Date: 06/19/2025

Re: **Overhanging Sill Plate**
Location: Lot 58 Harrington Place (Broadway, NC)
JDS Project No.: RDU2506390
Date of Inspection: 06/18/2025

1 MONO-SLAB FOUNDATION PLAN
 SCALE: 1/4"=1'-0" ON 22x34
 1/8"=1'-0" ON 11x17
 ALL ELEV. SIM.

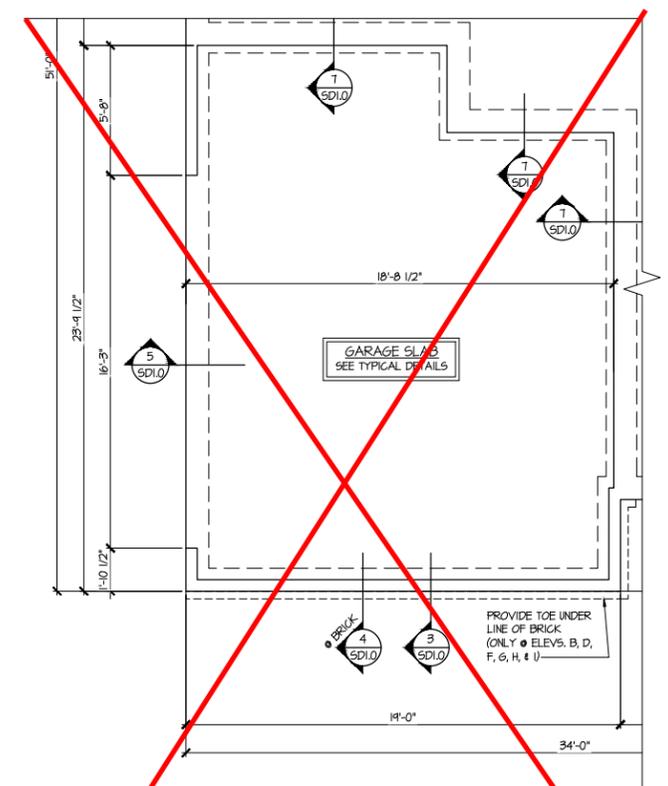
At the center of the rear wall of the garage, below the stairs, the sill plate overhangs the monolithic slab foundation 3/8" to 1/2".

Based on our onsite observations and review, the overhang does not significantly affect the capacity of the member. No repair is required.
